CITY OF ALBUQUERQUE
DEVELOPMENT REVIEW BOARD

M I N U T E S

January 29, 2020

Agenda Item 8
Project Number 2019-002184-Site Plan

LANDSCAPE PLAN

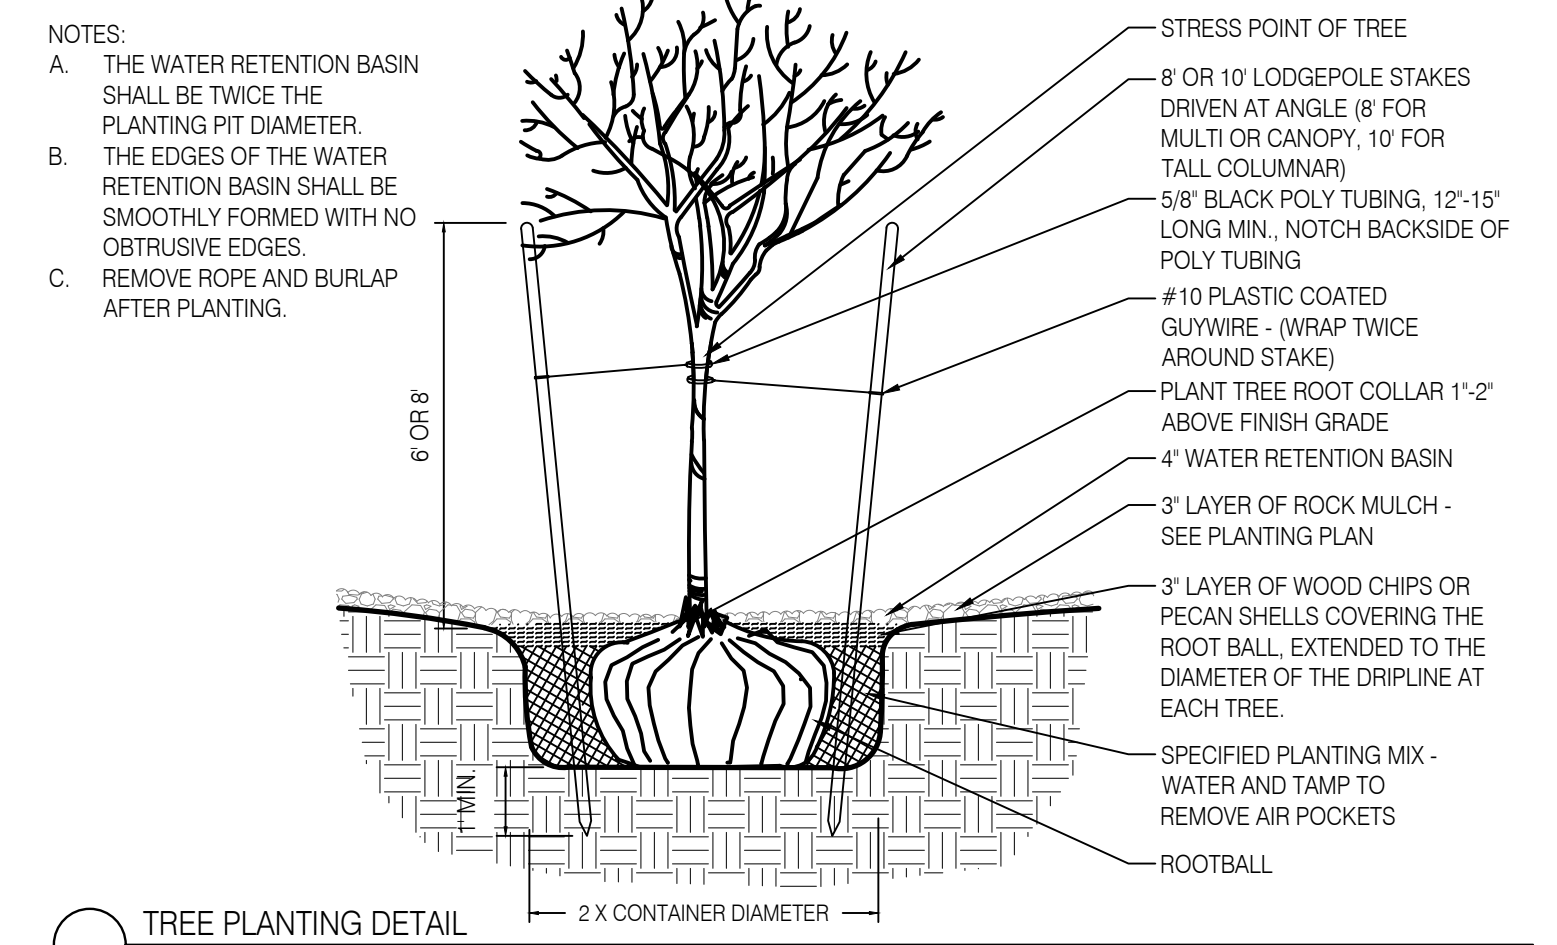
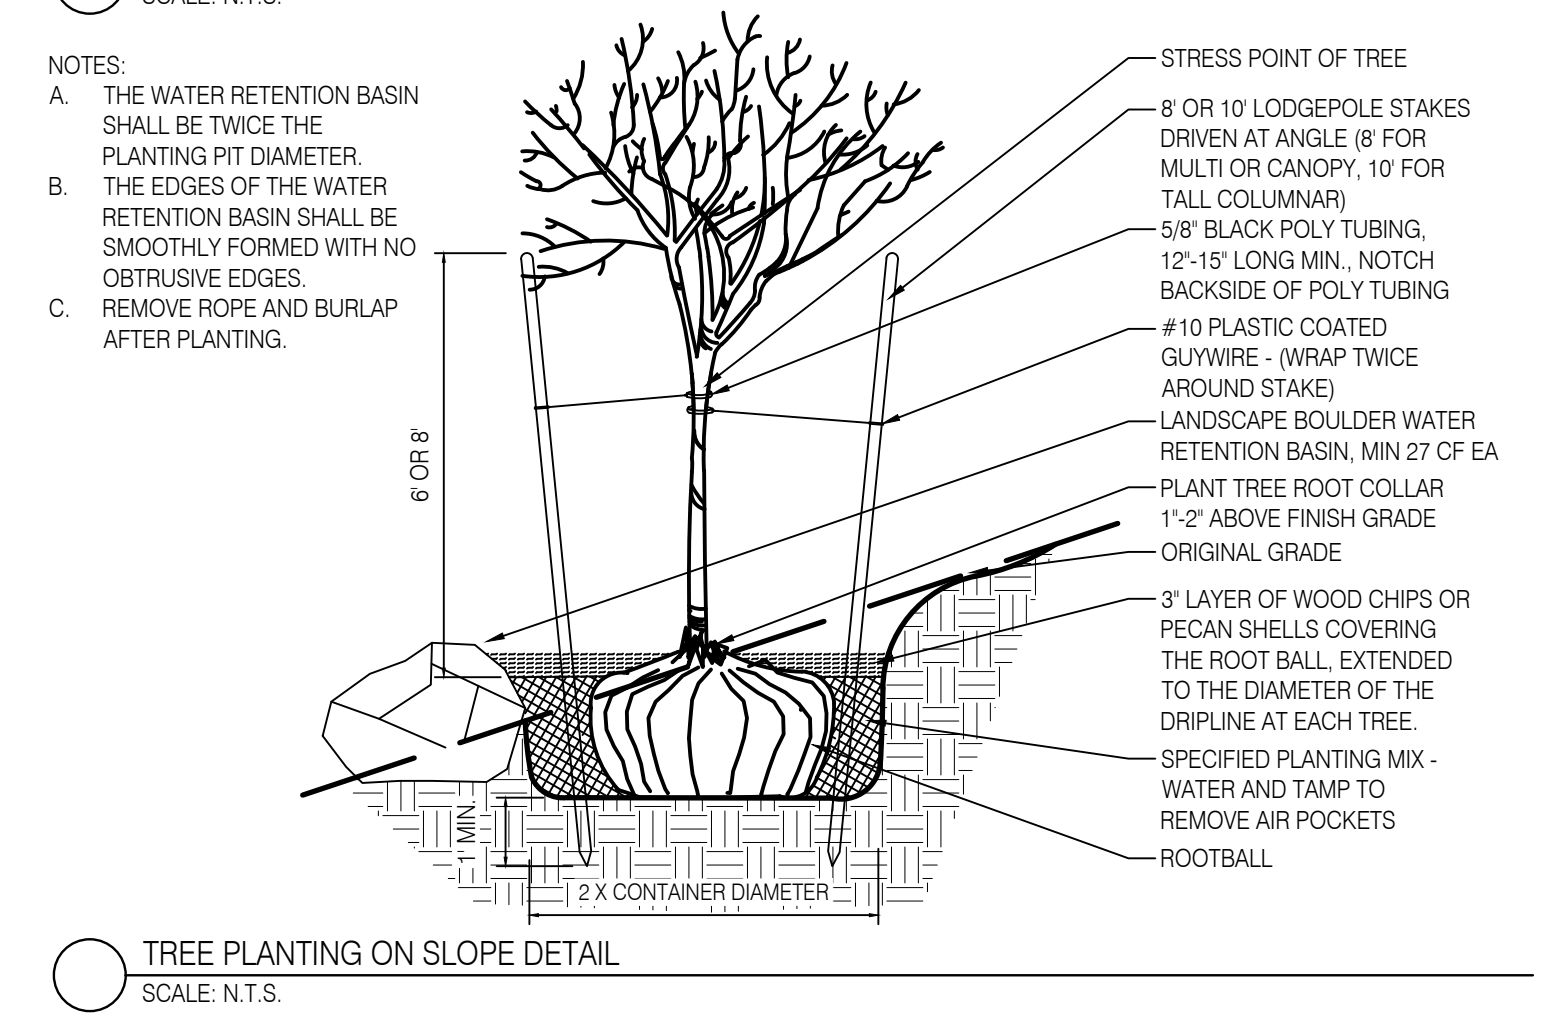
With regard to the site plan, if you could just show me that change of vegetation.

The irrigation service is great. Okay. And for information only, you have an availability Statement 190317 which provides the conditions for service. Thank you.

SITE PLAN - DRB

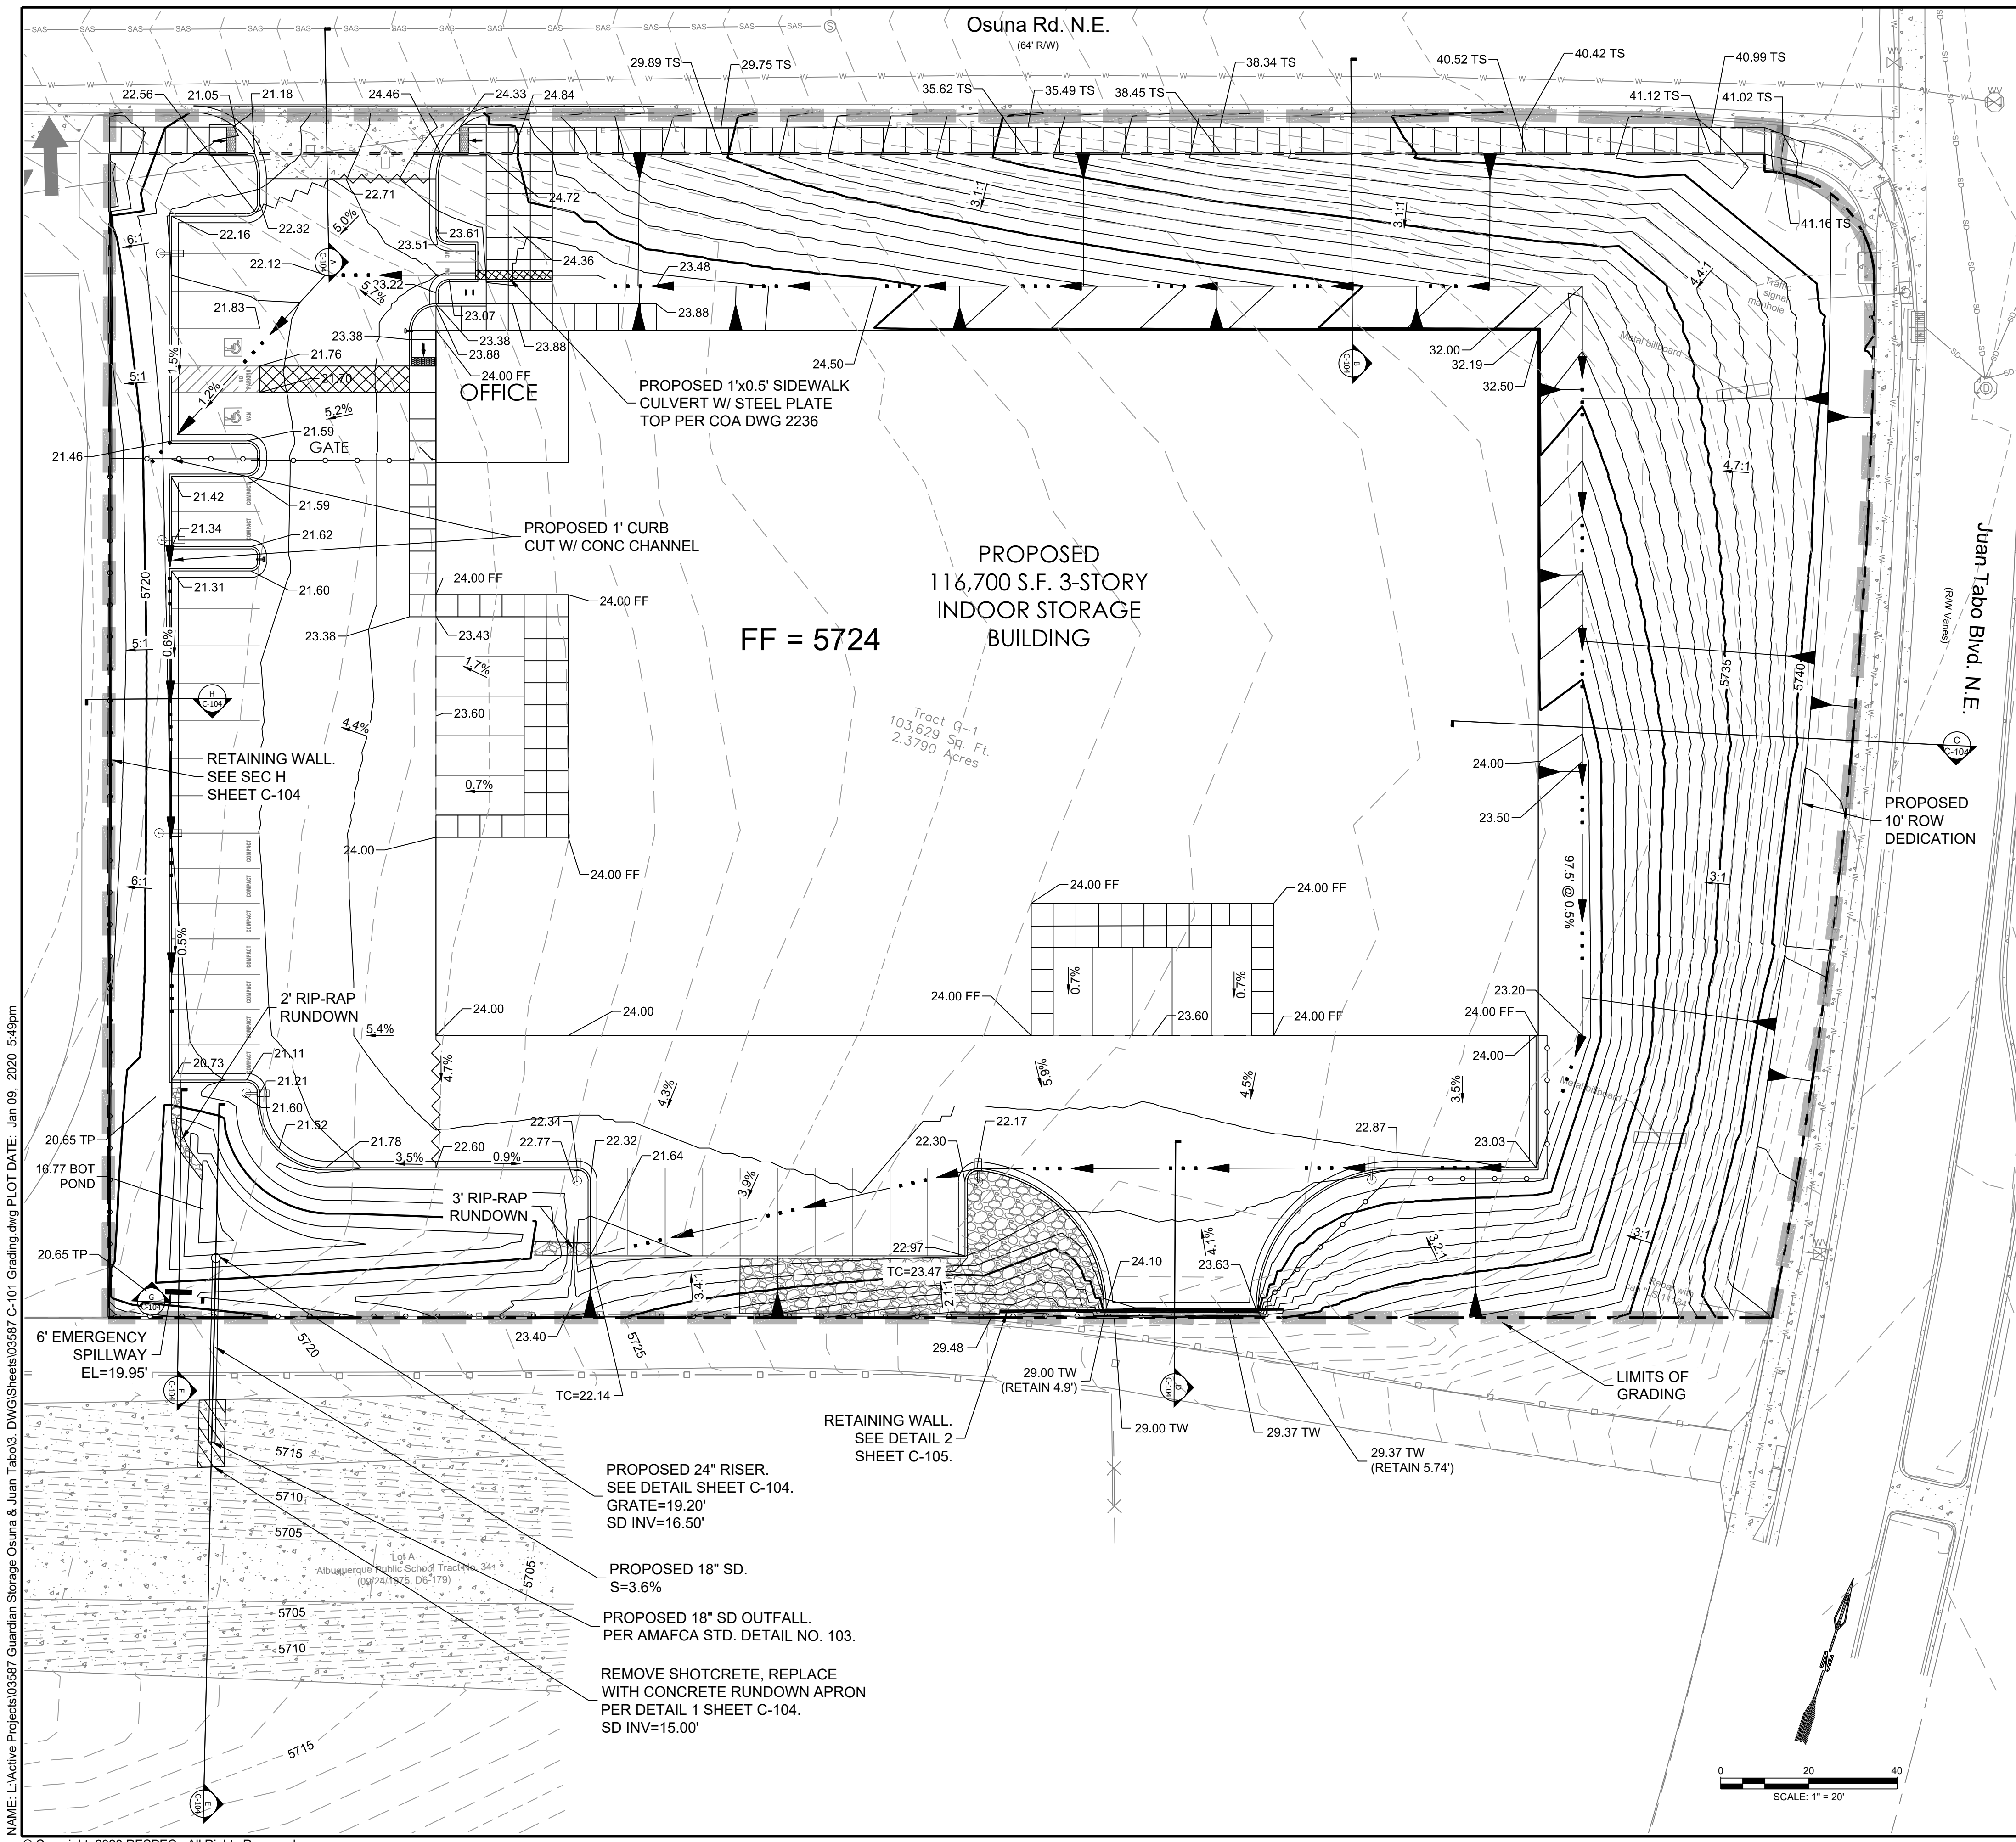
I did receive the fire marshal stamped plan. That was sent to me by e-mail, however, I still had a few remaining comments that I didn't see addressed by e-mail. And they were minor comments, such as including the stamp on the site plan showing the ADA cross slope on the drive pads. And also, calling out the city standard details for the drive pad and sidewalk.

And then there were some -- just some minor dimension park -- dimensioning on the parking island radii.

MS. WOLFENBARGER: Okay. You addressed by third comment. And then the references to the city standard details on the sidewalk and drive pad.

MR. STROZIER: I believe that we have addressed all of those, and I have a copy of the updated site plan with the stamp, engineer stamp site plan today, so --

UNIDENTIFIED MALE: So those will be on the work order.

MS. WOLFENBARGER: And that will be okay. So with the comments that you addressed, I -- I approve the site plan.

SHEET TITLE: CONCEPTUAL DRAINAGE PLAN

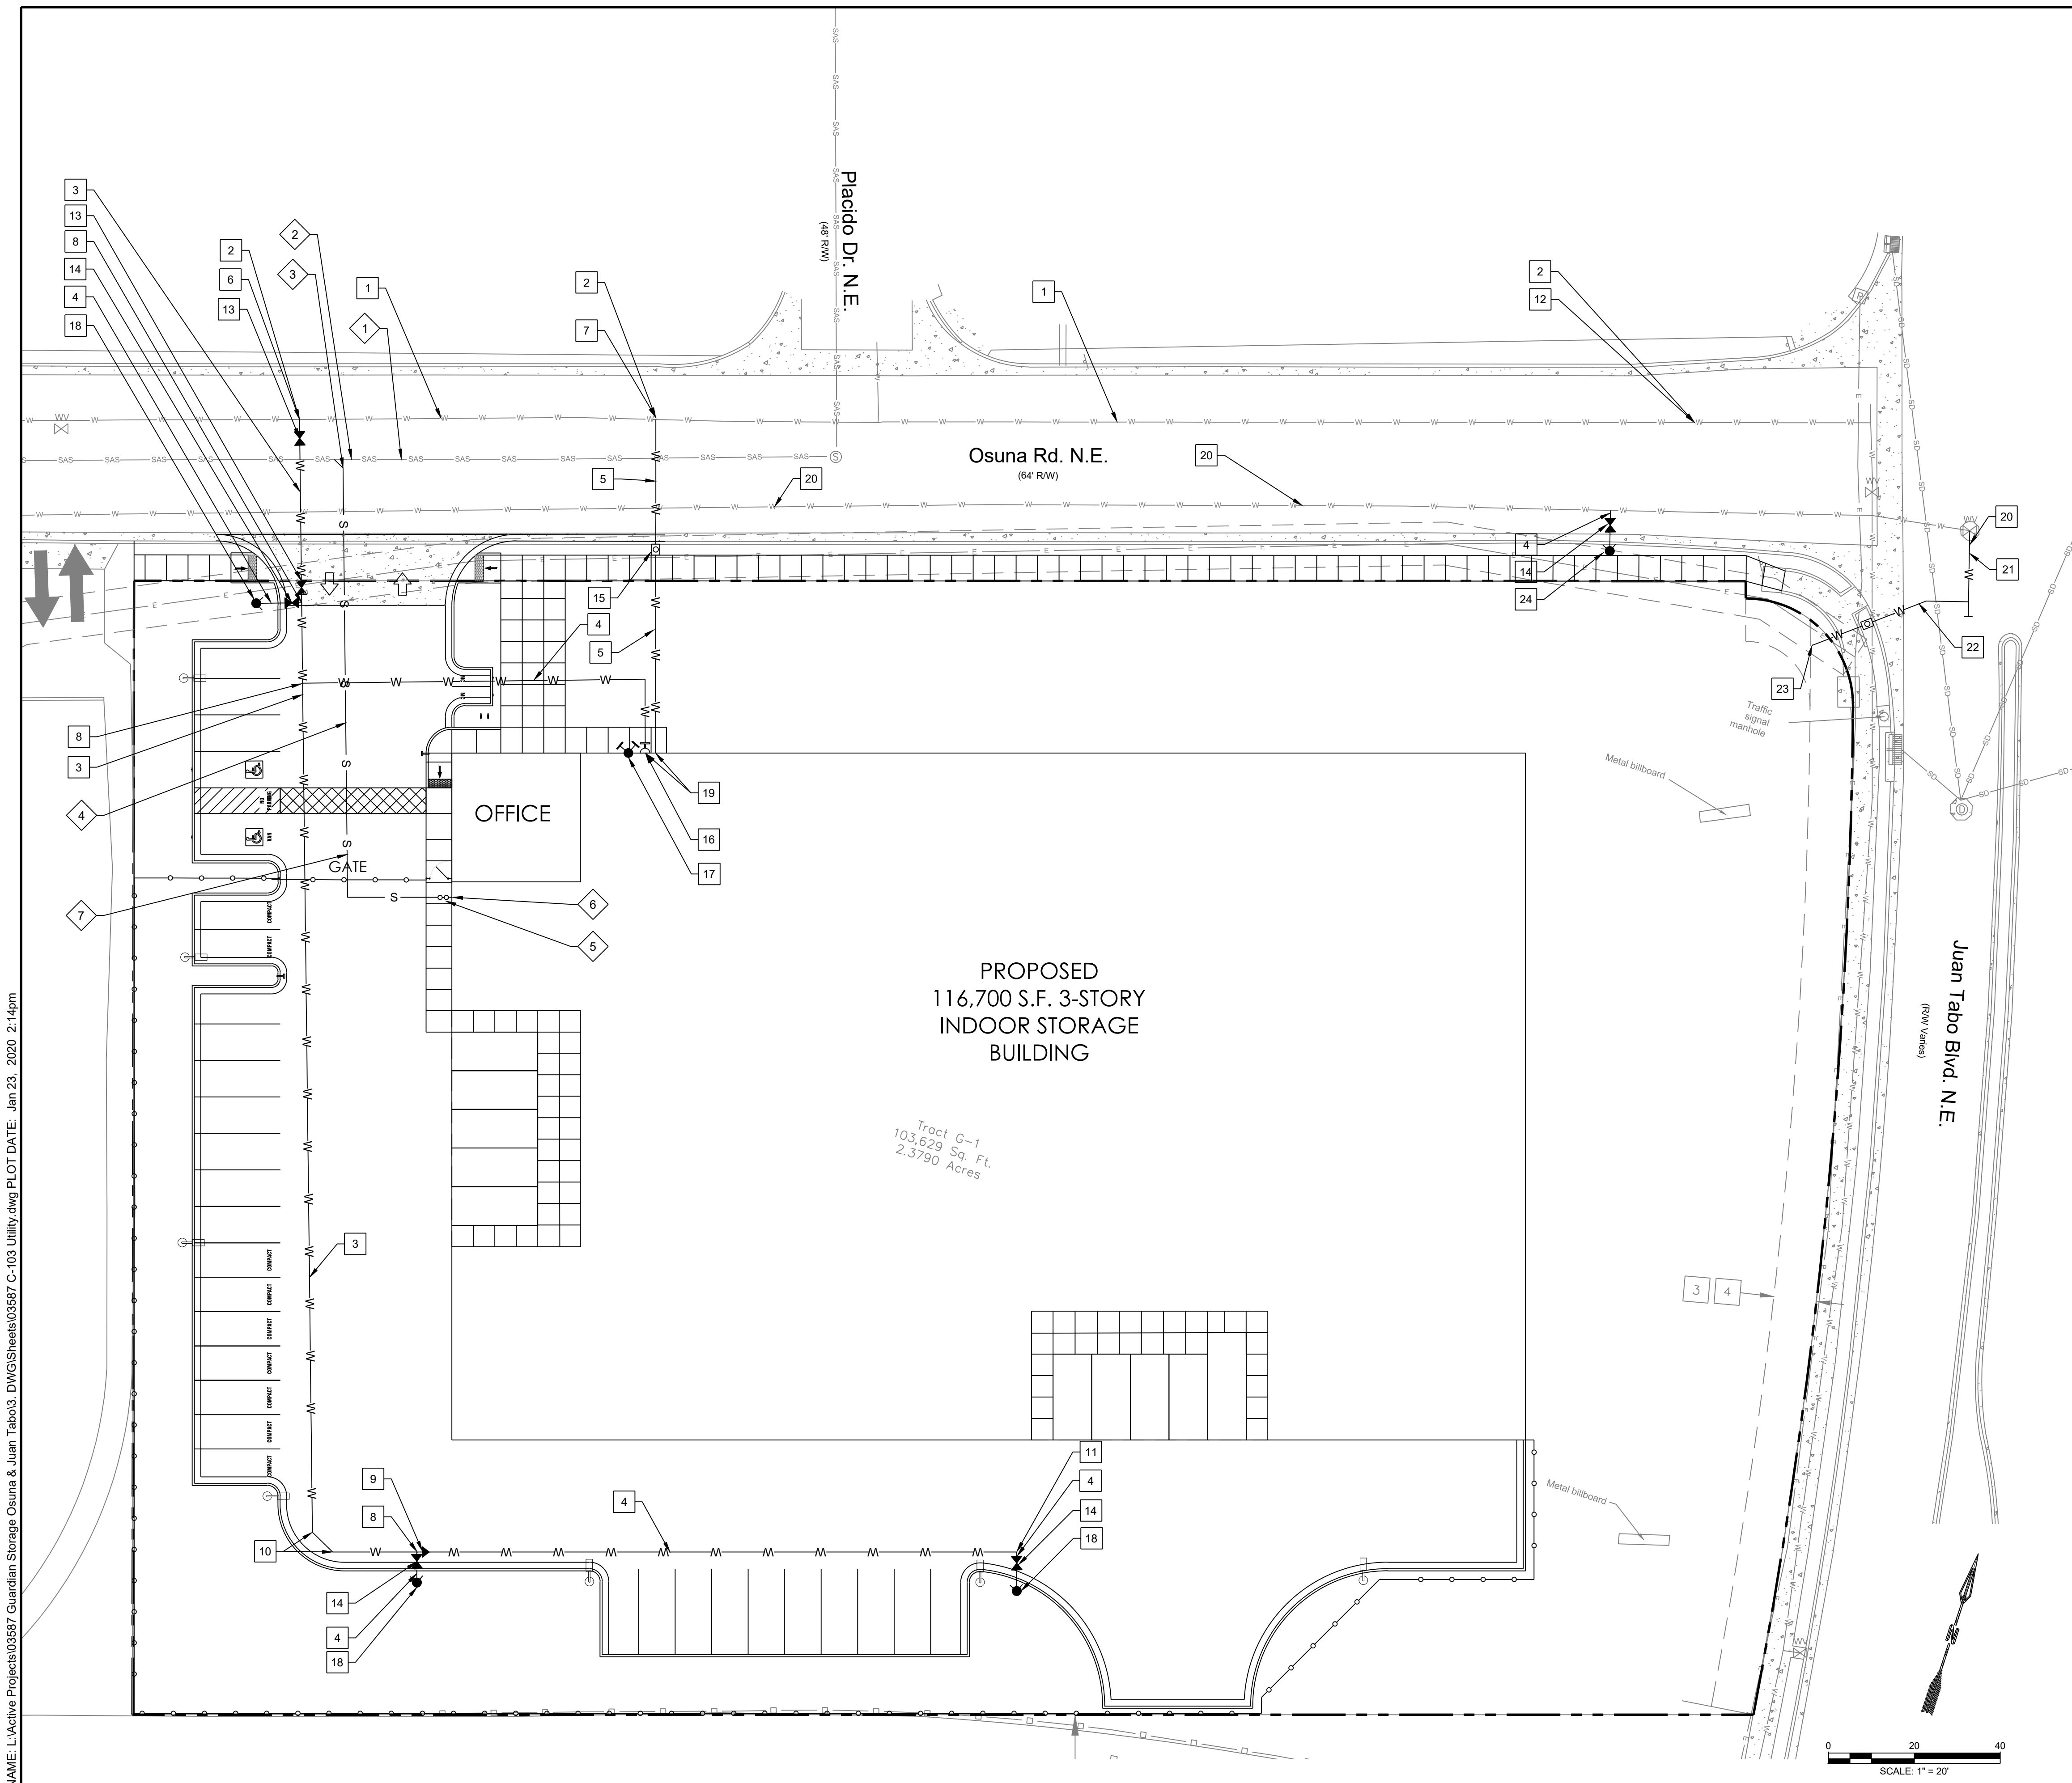
MR. BIAZAR: Hydrology has no objection to the plat. For the site plan, we have an approved conceptual grading and drainage plan with engineer stamp dates of December 20th, 2019, and January 9th, 2020. So we just need to make sure that the latest approved site plan is -- grading and drainage plan is included with the site plan.

MR. BIAZAR: They have a new stamp date on their grading and drainage plan. The last approved one was on January 9th, and they have one that's now stamped the 23rd, so we would need to --

MR. BIAZAR: Hydrology takes delegation for -- to recheck the grading and drainage plan. We can say four weeks. I think it'll be done much quicker.
